Lime Down

Solar Park

Statement of Common Ground with Natural England (Tracked)

Document Reference: EXAM/8.4

Title:
Figure 4-4: Main Infrastructure Layout Changes between PEIR and DCO Application

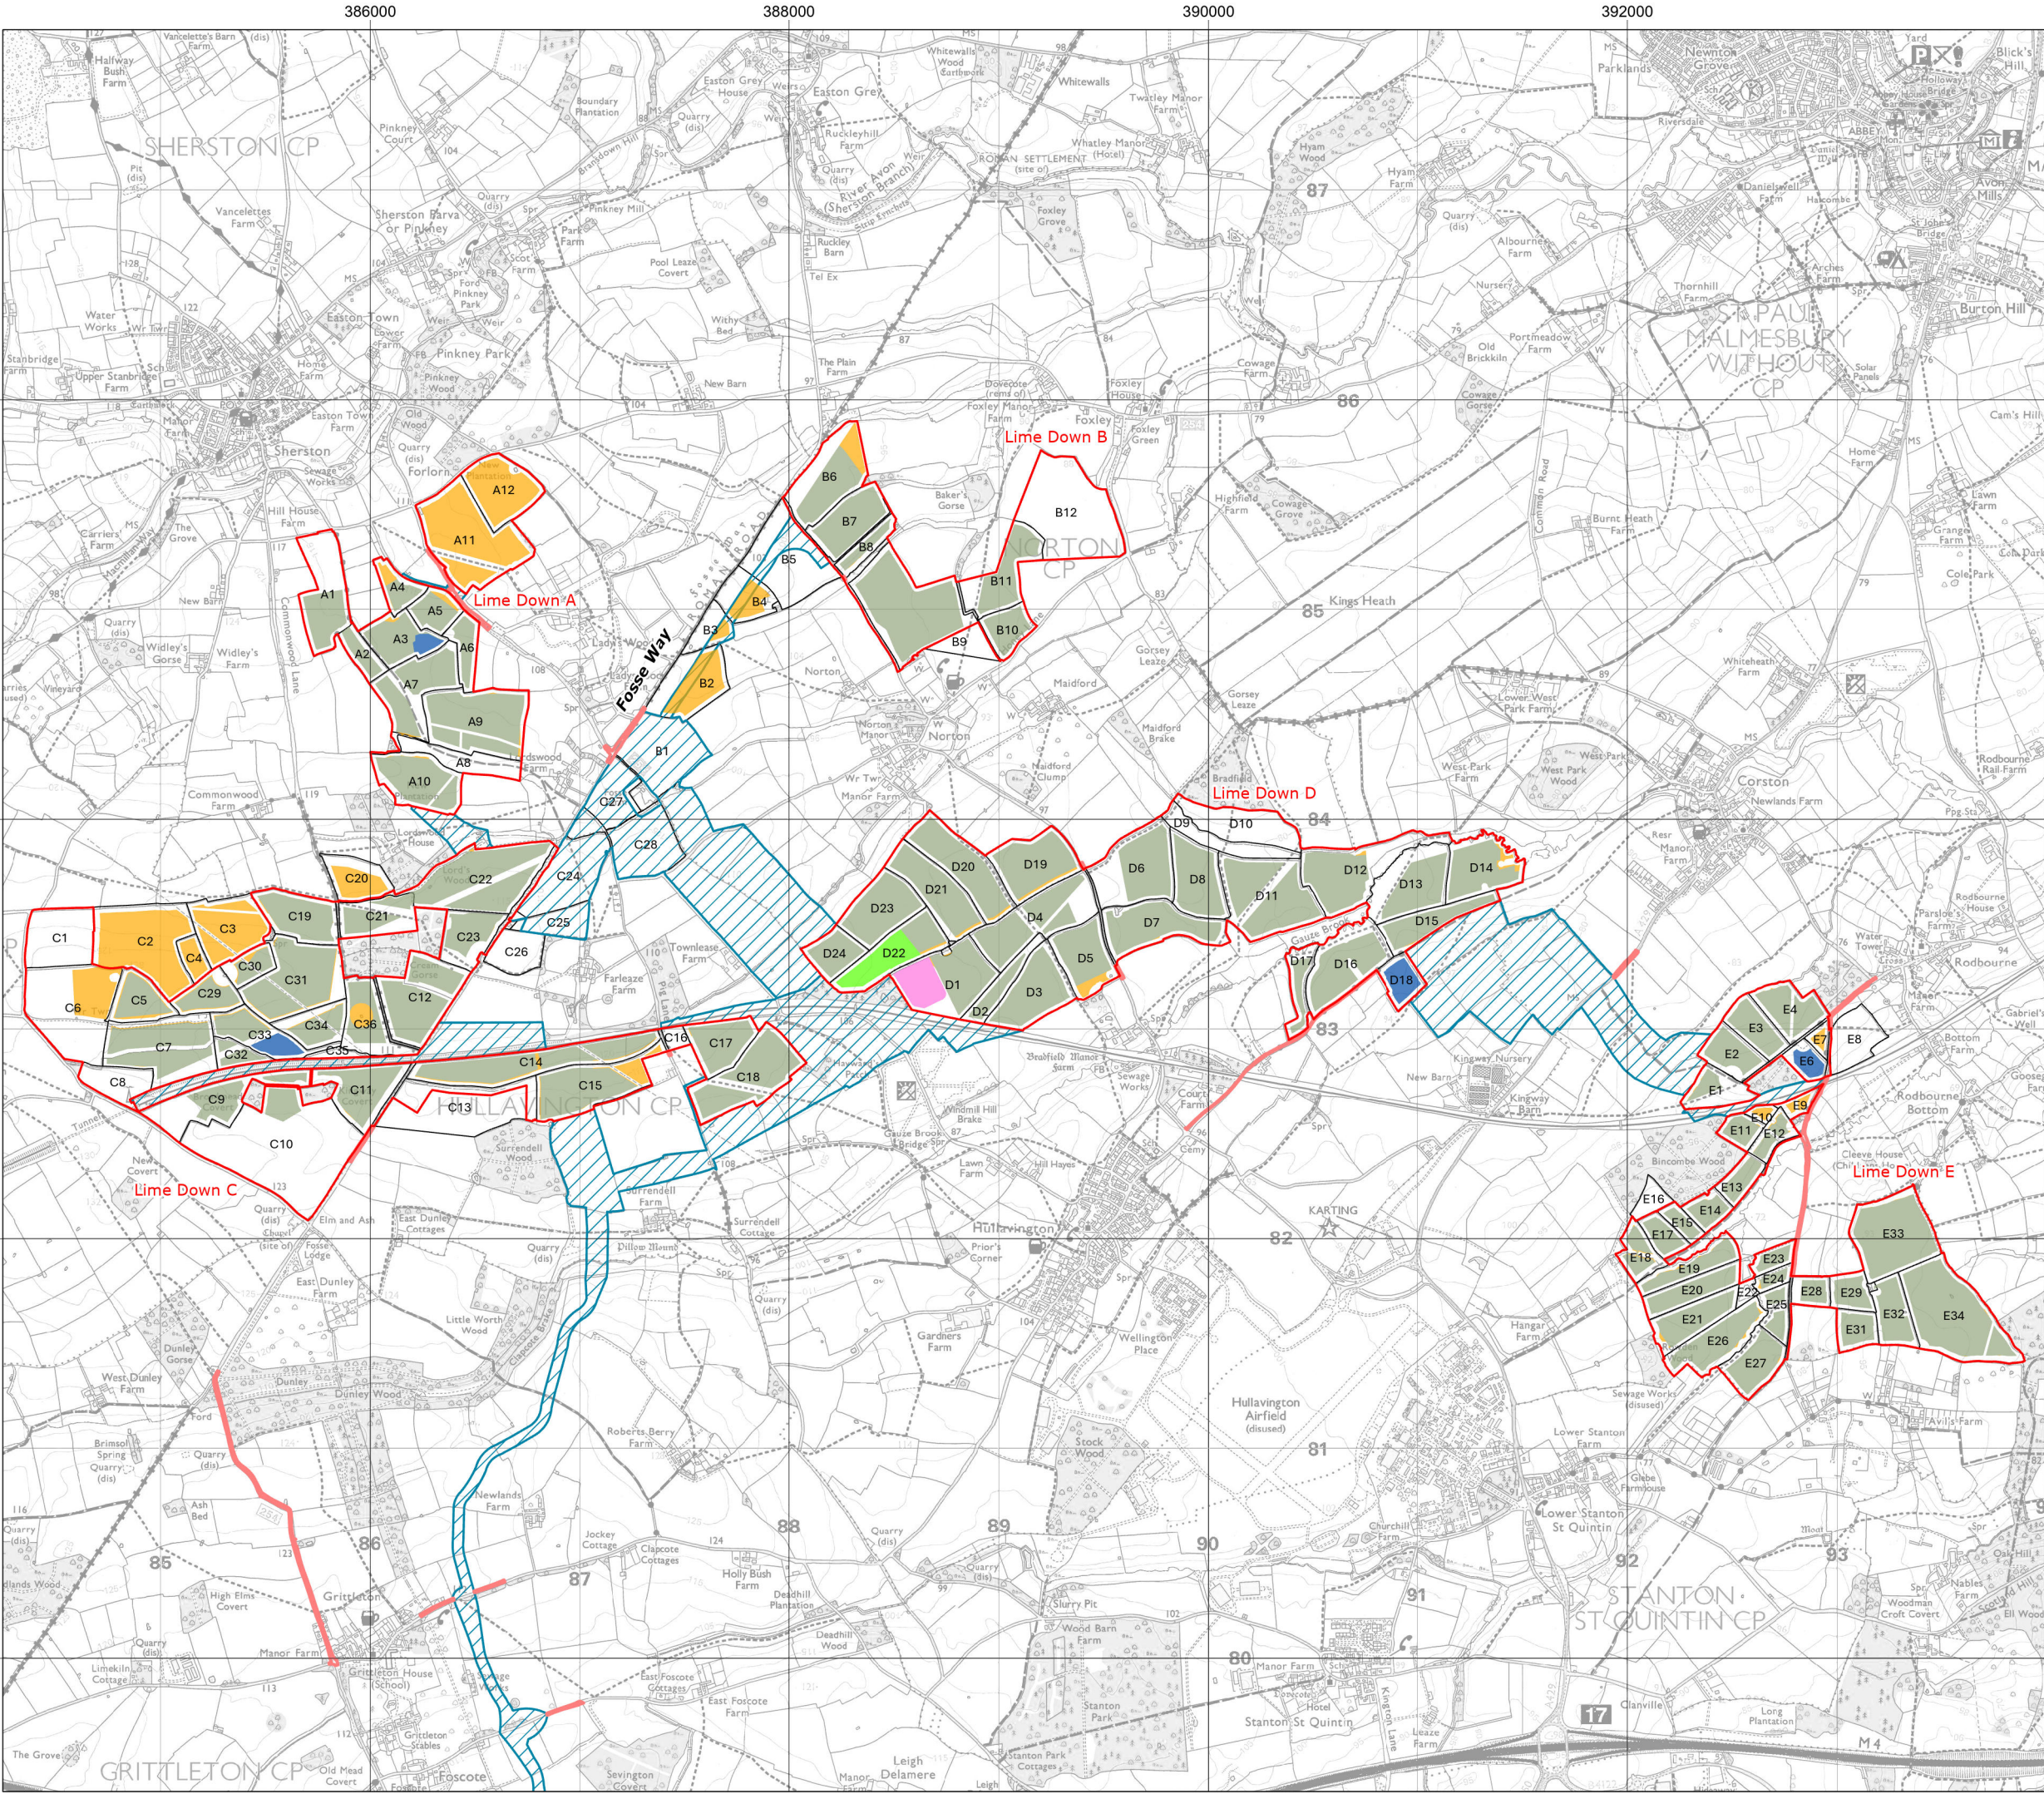
Reference	Sub-topic	NE Position	Applicants Position	Status
3.1.1	Extent of panels within Lime Down C	Recommended that the extent of panels within Lime Down C is reviewed to avoid adverse landscape and visual effects on the CNL. Where panel areas are reduced, this should be used to provide landscape and ecological enhancements, particularly for lesser horseshoe bats.	As shown on the Works Plan, panels will not be located in the parts of fields directly adjacent to the National Landscape boundary within fields C1, C6, C8, and C10 retained clear of panels. Photomontages from 13 viewpoints demonstrates that this limits the landscape and visual impact of the proposed development.	Under Discussion

Drawing file: published-documents / EN010168-000768-6.2 Figure 13-11 Construction Access Locations Solar PV Sites.pdf

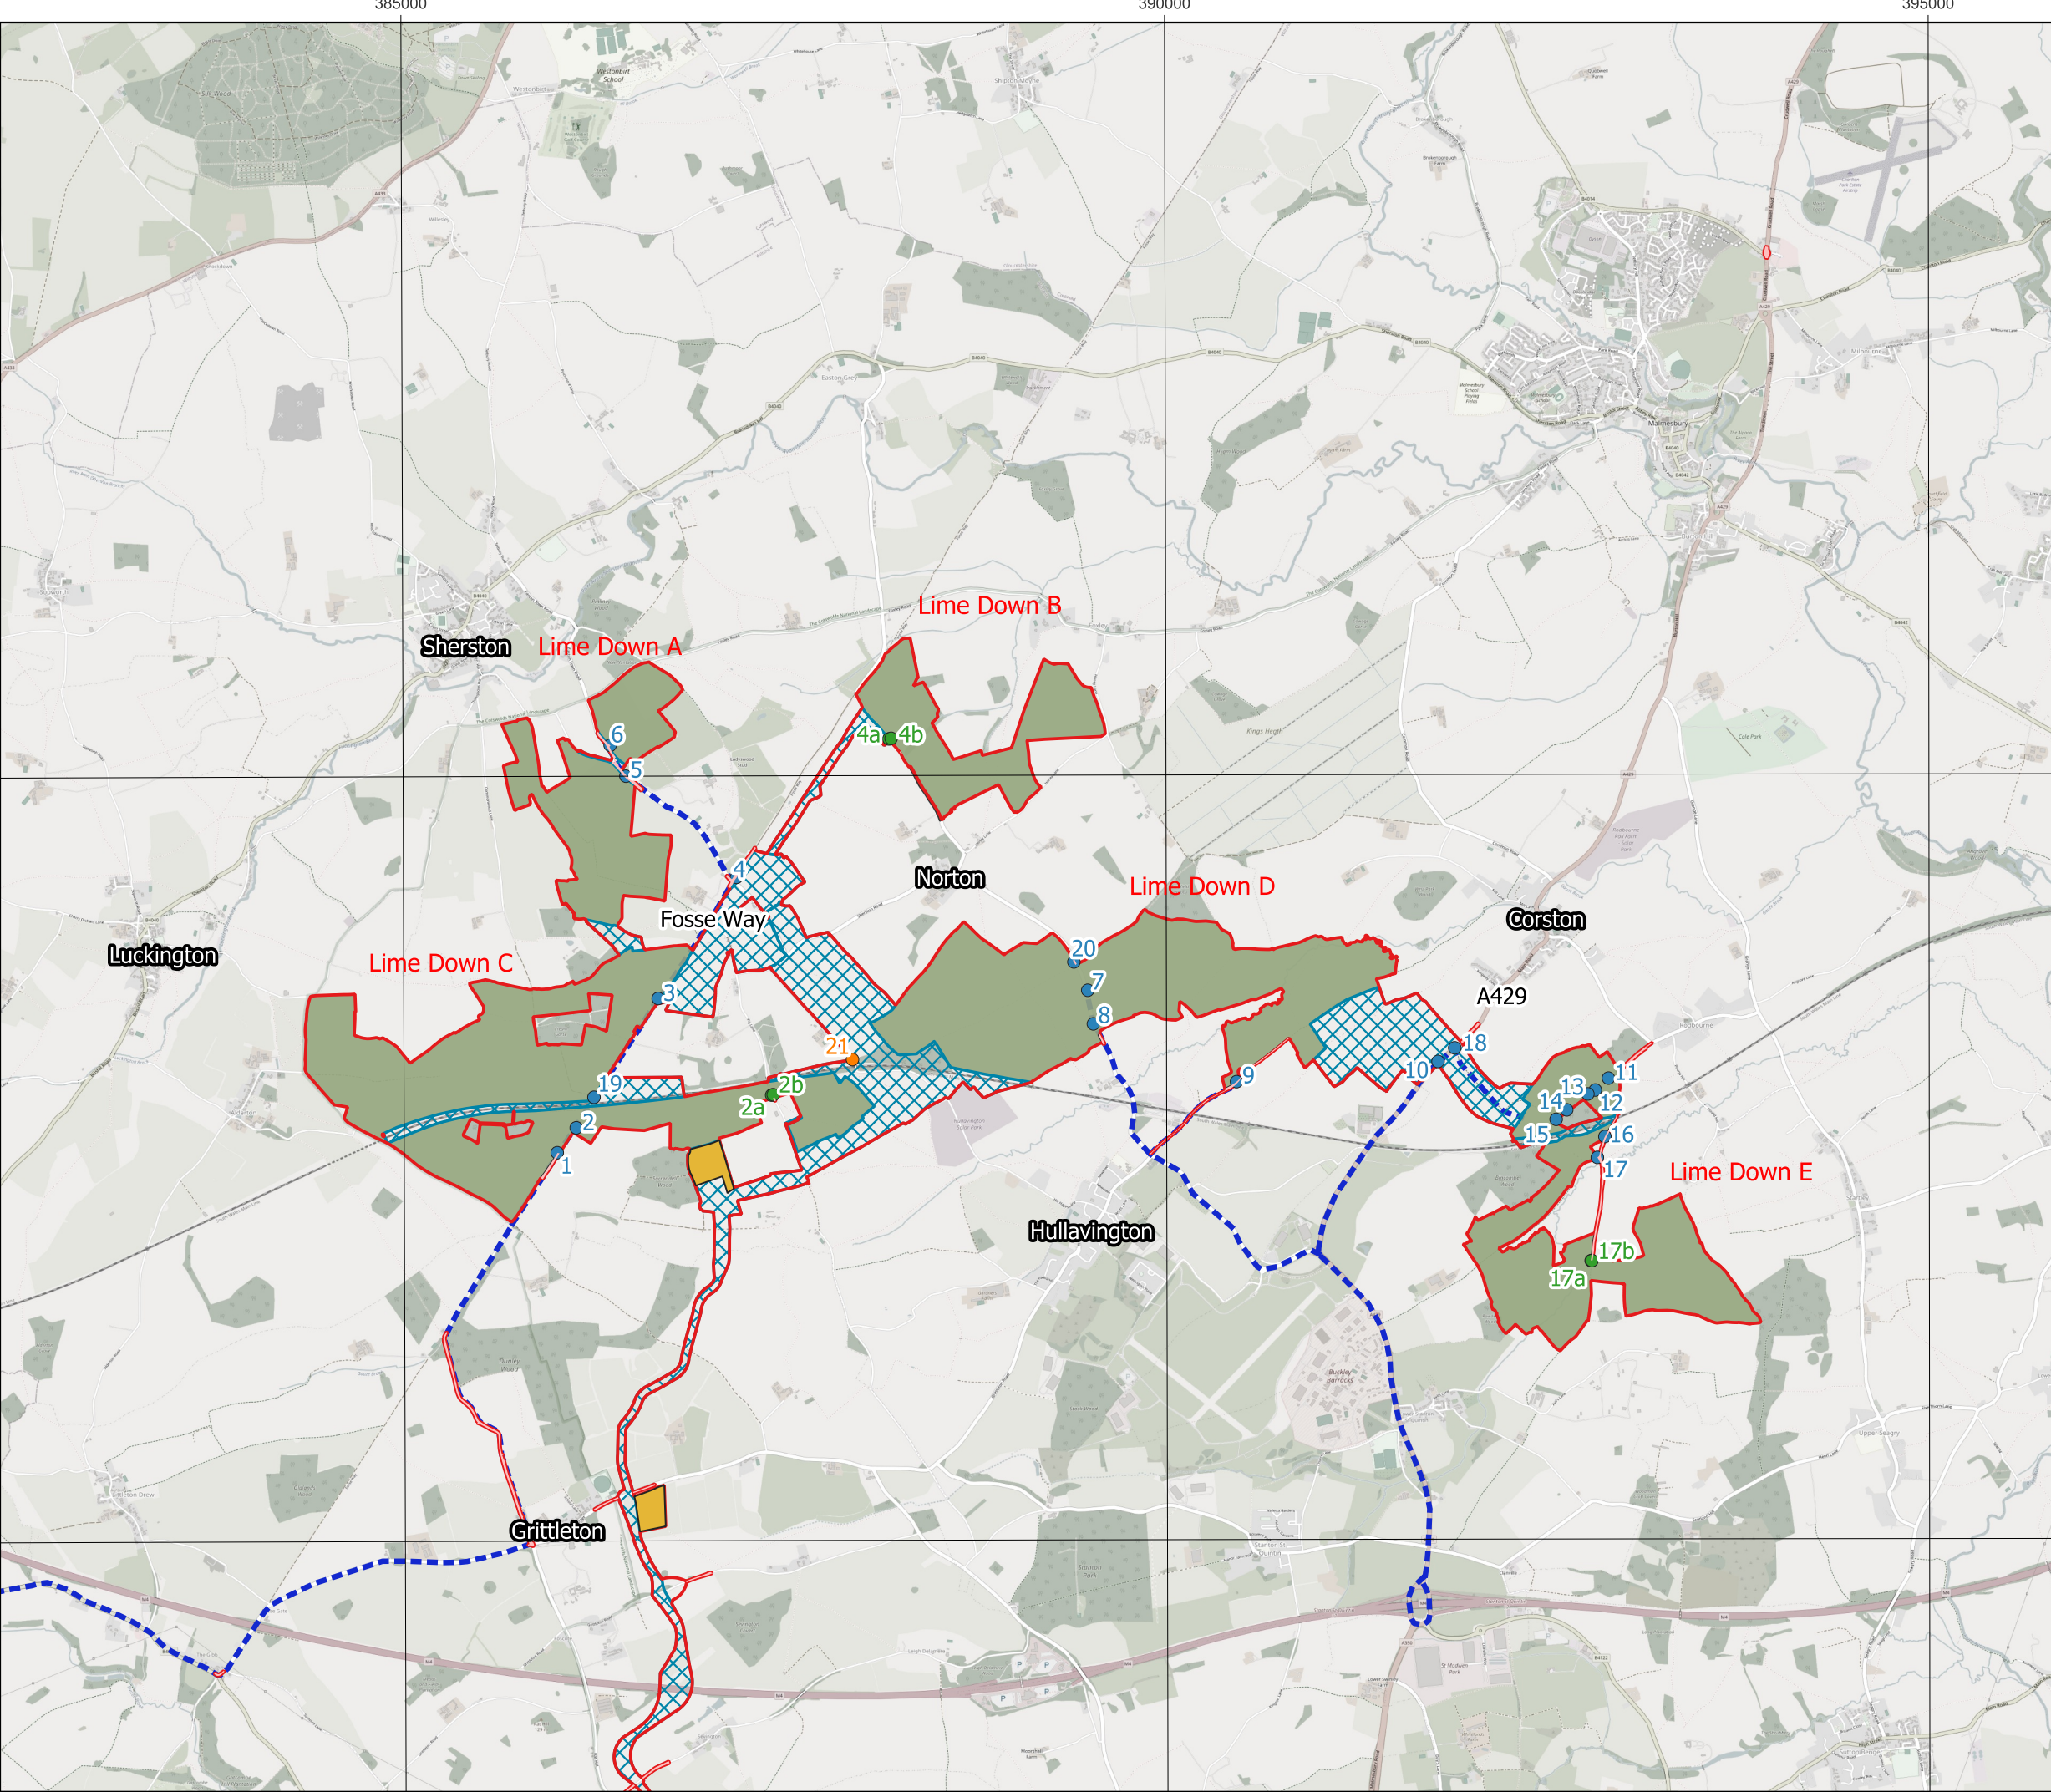
Reference	Sub-topic	NE Position	Applicants Position	Status
		<p>Assessment, including the Zone of Influence and the list of internationally designated sites, and confirms that Salisbury Plain SPA can be scoped out.</p> <p>For the Bath and Bradford on Avon Bats SAC, Natural England agrees that the solar PV site itself is not functionally linked land for greater horseshoe bats. However, the cable route corridor lies within an impact zone and could be functionally linked, meaning likely significant effects cannot be ruled out due to potential loss or fragmentation of commuting habitat. Impacts relating to loss of roosts, killing, or injury of greater horseshoe bats can be screened out.</p> <p>In relation to lesser horseshoe bats, while the HRA concludes the solar PV sites are not functionally linked, Natural England notes survey evidence showing regular early-night activity at Lime Down C, suggesting nearby roosting and potential functional linkage to the SAC. Although loss of</p>	<p>representing functionally-linked land for lesser horseshoe bats associated with the Bath and Bradford-on-Avon Bats SAC. An updated version of the Habitat Regulations Assessment Report [EN010168/APP-275/7.10 (Rev 2)] will be prepared accordingly and submitted at Deadline 3.</p> <p>Natural England and the Applicant have reached agreement on the mitigation measures which would need to be included within Lime Down C to ensure that significant impacts to SAC lesser horseshoe bats resulting from fragmentation could be avoided.</p> <p>These measures comprise:</p> <ol style="list-style-type: none"> a. Retention of hedgerows across Lime Down C with any required new gaps in hedgerows to be limited to a maximum of 10m (it is understood that a majority will be limited to 3.5 – 6m) with the exception of one larger gap of 12 – 14m for the proposed access off the Fosse Way.

Reference	Sub-topic	NE Position	Applicants Position	Status
		<p>foraging habitat is unlikely to result in significant effects, potential fragmentation of commuting routes within Lime Down C should be screened in for Appropriate Assessment.</p> <p>For Bechstein’s bats, Natural England agrees that likely significant effects from loss or change to functionally linked land can be screened out due to distance, lack of suitable habitat, and absence of records. Evidence to date does not indicate functional linkage to the SAC, and impacts related to fragmentation, roost loss, or killing and injury are considered unlikely.</p> <p><u>Updated Position</u></p> <p><u>It is agreed that a vast majority of the habitat within Lime Down C provides suboptimal foraging habitat for lesser horseshoe bats. It is noted that the design of the proposed development has retained a majority of the hedgerows within Lime Down C and that losses have been</u></p>	<p>b. Construction Lighting will be controlled to prevent light spill onto suitable commuting habitats.</p> <p>The Outline Ecological Protection and Mitigation Strategy (EPMS) [REP1-106] details how sections of hedgerow to be permanently removed for new internal access tracks where no existing gap is present will typically be between 3.5 m to 6 m wide, with a maximum of 10 m of hedgerow to be removed in any one location for this element of the Scheme. It also details how sections of hedgerow to be removed to provide access from the existing highway network, including for Abnormal Indivisible Loads (AIL) will require a maximum of 18 m of hedgerow loss at any one access point, although would typically be less than this at most access points. At Lime Down C one AIL Location is expected to comprise a gap of 12 – 14 m in width, at Solar PV Access Location 19 (ES Volume 2, Figure 13-11 Construction Access Locations:</p>

Reference	Sub-topic	NE Position	Applicants Position	Status
		<p><u>minimised. However, due to the reasoning stated in the <i>Habitats Regulations Assessment Report</i>, we agree that likely significant effects on the Bath and Bradford on Avon Bats SAC as a result of loss of foraging habitat cannot be screened out.</u></p> <p><u>Further, whilst a majority of the hedgerows in Lime Down C have been retained, it is noted that hedgerow gaps will need to be created in a number of areas to facilitate access. Further, uncontrolled artificial lighting could impede lesser horseshoe commuting activity across the site. Therefore, due to the reasoning stated in the <i>Habitats Regulations Assessment Report</i>, we agree that likely significant effects on the Bath and Bradford on Avon Bats SAC as a result of fragmentation cannot be screened out.</u></p> <p><u>Mitigation measures for loss of foraging habitat include the establishment of 15m buffer zones to all hedgerows and woodland across the Solar PV</u></p>	<p>Solar PV Sites [APP-156] refers). Appropriate limitations and controls for the use of artificial lighting during construction, designed to avoid impacts on bats and other light-sensitive species are detailed within the Outline EPMS [REP1-106] as well as the Outline Construction Environmental Management Plan (CEMP) [REP1-096].</p> <p>Measures set out within the Outline EPMS [REP1-106] and the Outline CEMP [REP1-096] are secured by Requirements 8 and 13 respectively within the Draft Development Consent Order [REP1-007].</p> <p><u>On 3 June 2026</u> the Applicant will continue to engage provided NE with Natural England on this matter and welcomes Natural England's review <u>an advanced copy</u> of the revised Habitat Regulations Assessment Report [EN010168/APP-275]/7.10 (Rev 2) to be submitted at Deadline 3, at which point. <u>On 12 June 2026 NE responded</u></p>

Reference	Sub-topic	NE Position	Applicants Position	Status
		<p><u>site. Further, it is noted that habitat creation and enhancement works will be undertaken across the solar PV site which will result in an overall increase in foraging value within Lime Down C. Therefore, subject to all measures detailed in the <i>Habitats Regulations Assessment Report</i> being secured in the DCO, we agree that adverse effects on the integrity of the Bath and Bradford on Avon Bats SAC as a result of loss of foraging habitat can be ruled out.</u></p> <p><u>Mitigation to reduce fragmentation impacts includes limiting the width of hedgerow gaps in Lime Down C. It is noted that there will be one larger gap which will be required to be created in Lime Down C for Abnormal Indivisible Loads. The retention of the vast majority of the linear habitat network will enable lesser horseshoe bats to maintain commuting activity across Lime Down C despite the hedgerow gap created for the AIL.</u></p>	<p><u>to confirm agreement with the revised document, and it is anticipated that</u> considered <u>full agreement on this matter can be</u> has now been <u>reached with</u> between <u>both parties.</u></p>

Reference	Sub-topic	NE Position	Applicants Position	Status
		<p><u>Provided that the minimisation of hedgerow gaps as detailed in the Habitats Regulations Assessment Report and the mitigation measures relating to construction lighting are applied in Lime Down C in addition to other sensitive areas of the application site, we agree that adverse effects on the integrity of the Bath and Bradford on Avon Bats SAC as a result of fragmentation can be ruled out.</u></p>
